Our ref: DOC22/747958
Your ref: SSD-36778089

Subject: Advice on EIS - Ryde Hospital Redevelopment (SSD-36778089) (City of Ryde)

The biodiversity development assessment report (BDAR) prepared by Ecological Australia, dated 22 July 2022 has been reviewed and EHG raises the following comments in relation to biodiversity impacts.

Figure 13 Overview showing TPZs & SRZs overlaid with development envelopes and proposed new internal roads. See Appendix 4 for accurate scale.

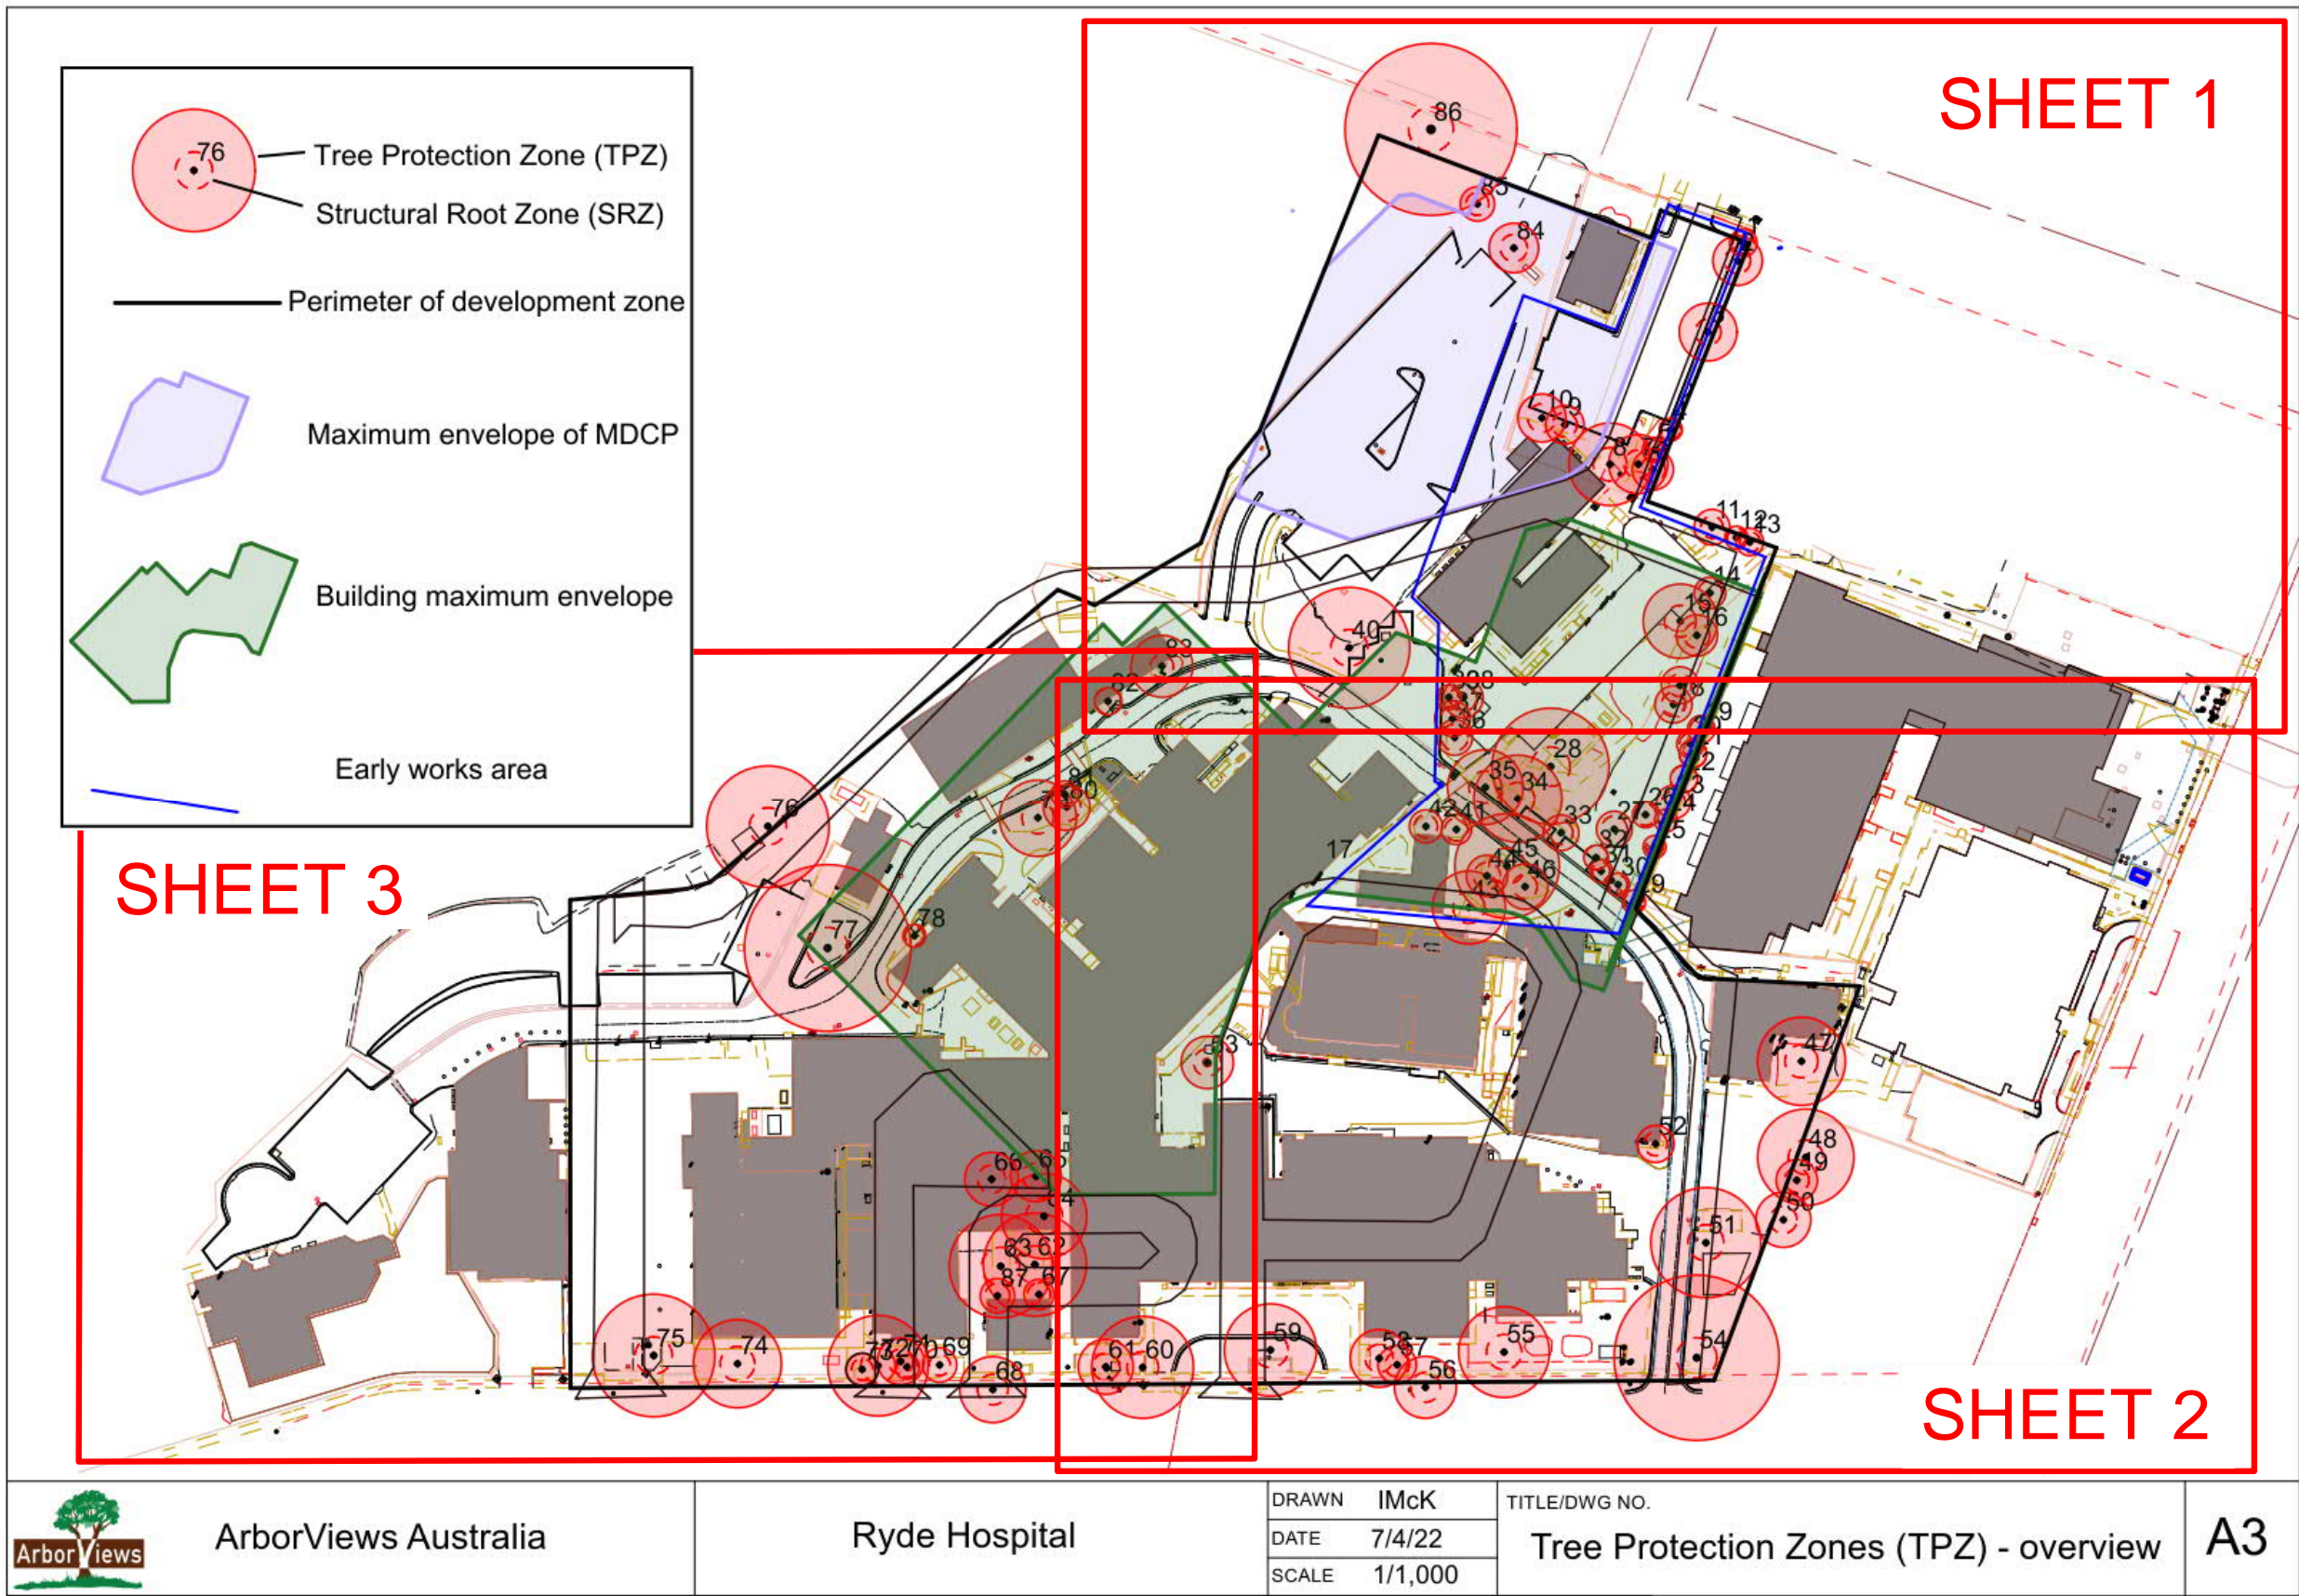
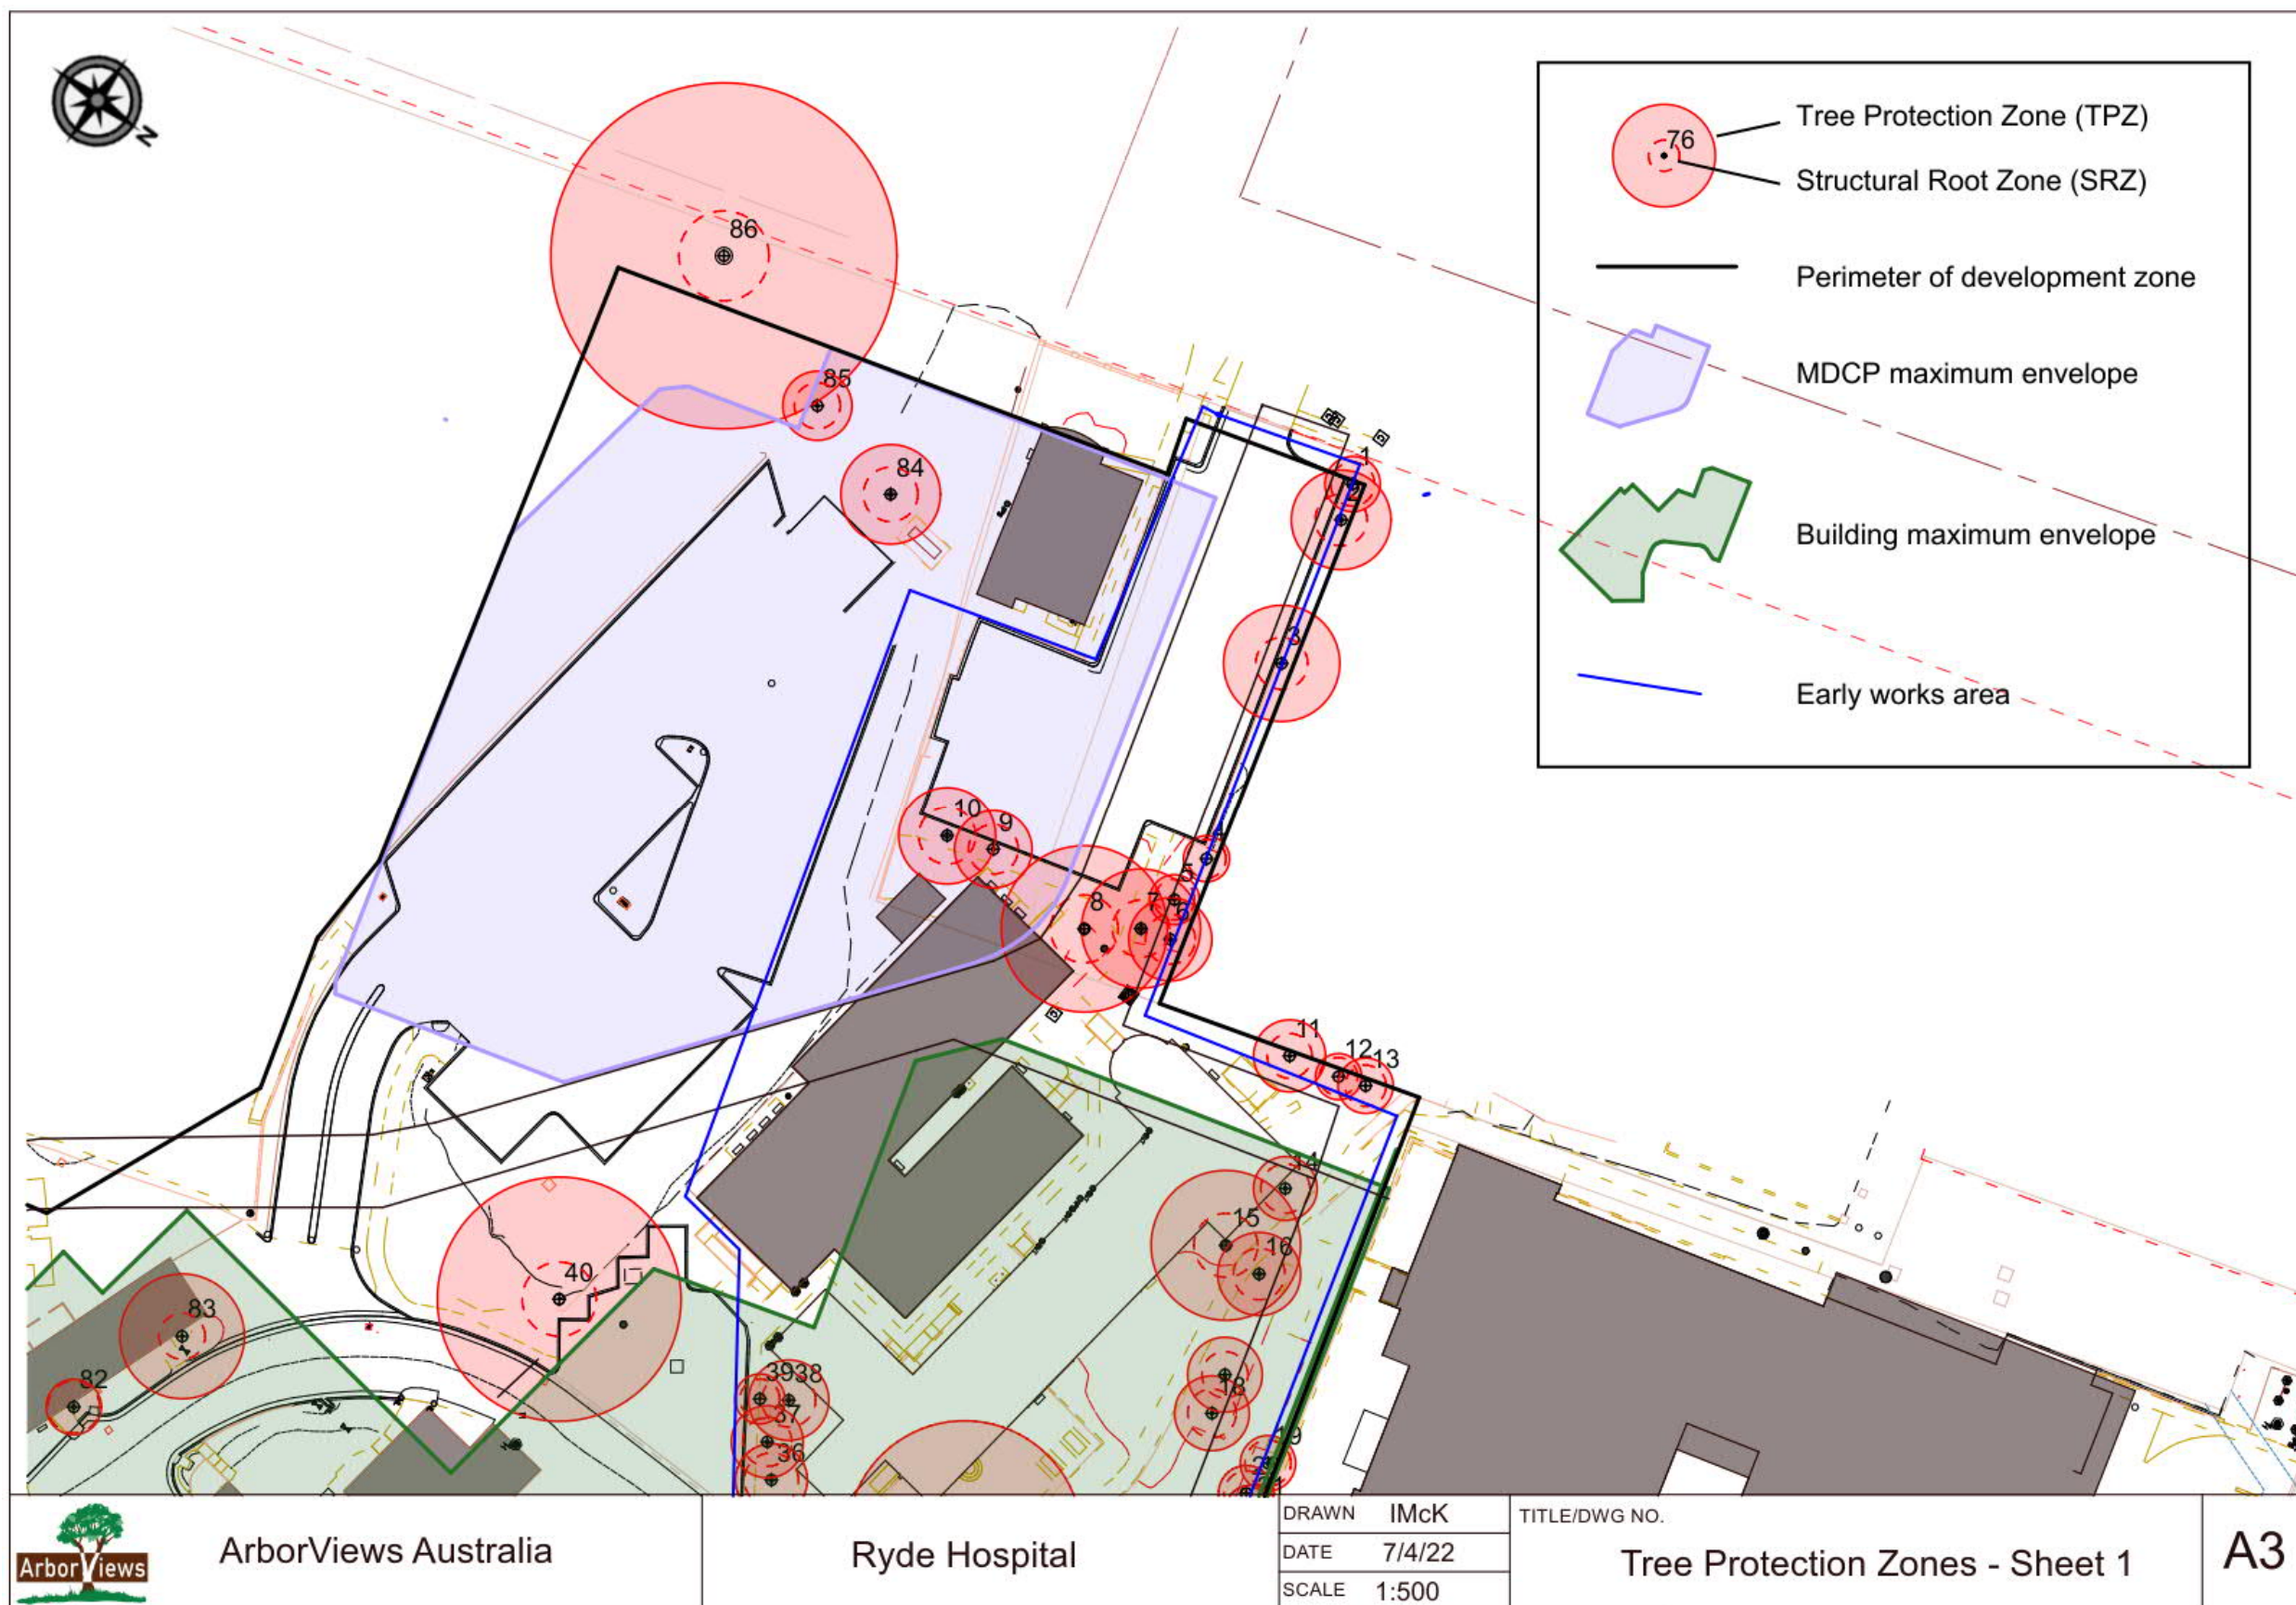
- Appendix 4: Site Plans with TPZs & SRZs of the AIA does not include all structures or works associated with the proposed development. EHG also considers it likely that there are additional trees on site that have not been mapped or included in the assessment, particularly along the edges of areas mapped as BGHF.

- An addendum to the AIA should be provided to address the above comments. A tree removal and retention plan based on the concept proposal and stage 1 layout should also be provided. Trees requiring removal and those to be retained and protection should be clearly identified on the plan. The location of any tree protection measures, such as TPZ fencing should also be identified on the plan.
